**KIRKLEES METROPOLITAN COUNCIL  
INVESTMENT & REGENERATION SERVICE**

**DELEGATED DECISION TO DETERMINE PLANNING APPLICATIONS TO  
CARRY OUT DEVELOPMENT WITHOUT COMPLIANCE WITH PLANNING  
CONDITIONS PREVIOUSLY ATTACHED**

Reference No:	<b>2025/70/92331/W</b>
Site Address:	Almondbury Working Mens Club, Southfield Road, Almondbury, Huddersfield, HD5 8RY
Description:	Variation of conditions 2 (plans), 3 (use of floors) and 4 (operating hours) of previous permission 2025/90480 for change of use of from working mens club to mixed use event hall (Sui Generis) incorporating Class E spaces and associated works
Recommending Officer:	Danielle Cooper

**DECISION – VARIATION OF CONDITIONS APPROVED**

Proposed Rear Elevation

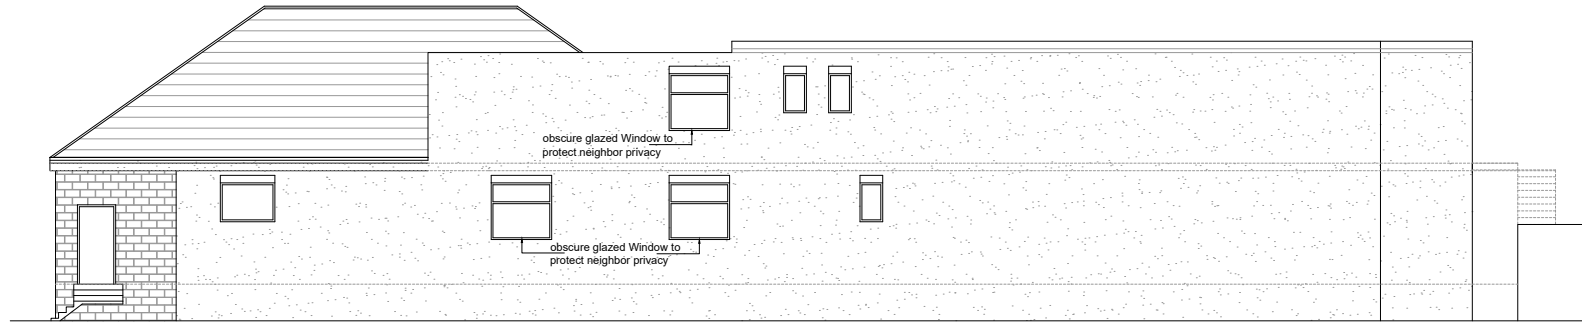
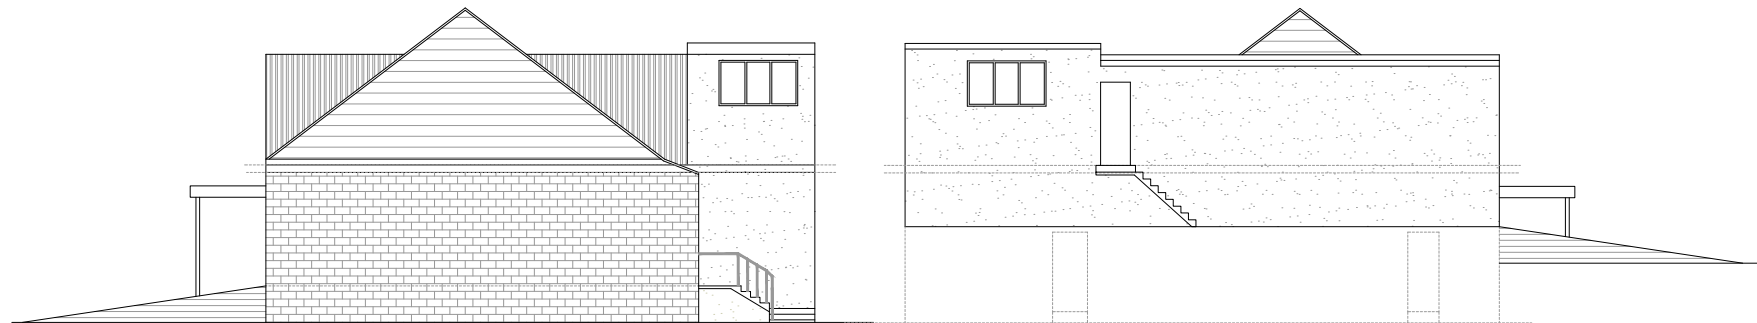
The applicant seeks to erect 4 additional windows to the rear elevation of the building, and a side door to the rear elevation of the building with a stair well.

The proposed two windows at ground floor level are indicated as obscure glazed and will a coffee shop and ‘room’. The proposed first floor windows will

serve a 'room' and 'in-suits'. The proposed first floor window serving a 'room' is annotated on plan to be obscure glazed.

All proposed rear windows are annotated as obscure glazed, and they will be non-opening below 1.7m.

As the proposed ground and first rear floor windows are obscure glazed, there will be no concern to loss of impact to the rear garden areas of No. 5 & 7 Sikes Close. The proposed first floor window serving a room will also be obscure glazed and as such raises no concern to loss of privacy to No. 5 & 7.

It is noted that a rear/side first door has been inserted as shown on the amended elevation plan with a stairwell and railings. The side door leads onto a flat roof. The agent has confirmed that this door has been inserted due to discussions with fire and safety it was recommended that an emergency exit staircase and new door should be provided in case of emergencies. The agent has confirmed that the flat roof of the rear structure will not be used as a balcony or terrace and will only be used for emergency purposes. This will be conditioned to ensure the flat roof is only used for fire emergencies.

9. The rear flat roof shall not be used as a balcony or terrace and will only be used as an exit route in the case of fire emergencies.  
*The above condition will be implemented to protect privacy levels of neighbouring occupants.*

The proposed new fenestrations on the front and rear elevation are considered to keep in character with the fenestrations on the host building and therefore raises no visual concern. The proposed roof lights are considered visually acceptable.

The proposed roller shutters to the front elevation of the fenestrations on the building will provide some securing to the commercial building and will only be shut when the building is not in use. The proposed roller shutters are therefore not considered to result in an adverse visual impact to the character of the host property or wider streetscape.

The proposed outdoor play area measures 7.6m (d) x 9.7m (w) and will be enclosed by a 1.8m fence with a planting buffer along the front elevation. The fencing and planting buffer is required for safeguarding. The proposed works are considered acceptable given that there is an historical precedent for an outdoor drinking area to the front of the site, as well as boundary treatments of fences with similar heights being located up to the pavement as seen along Southfield Road. The inclusion of a planted buffer along the front is also considered to soften the appearance of the outdoor play area to the front. As such, while the development will introduce a visual change to the street scene, the overall visual impact is not considered to result in adverse visual harm to the character of the streetscape.
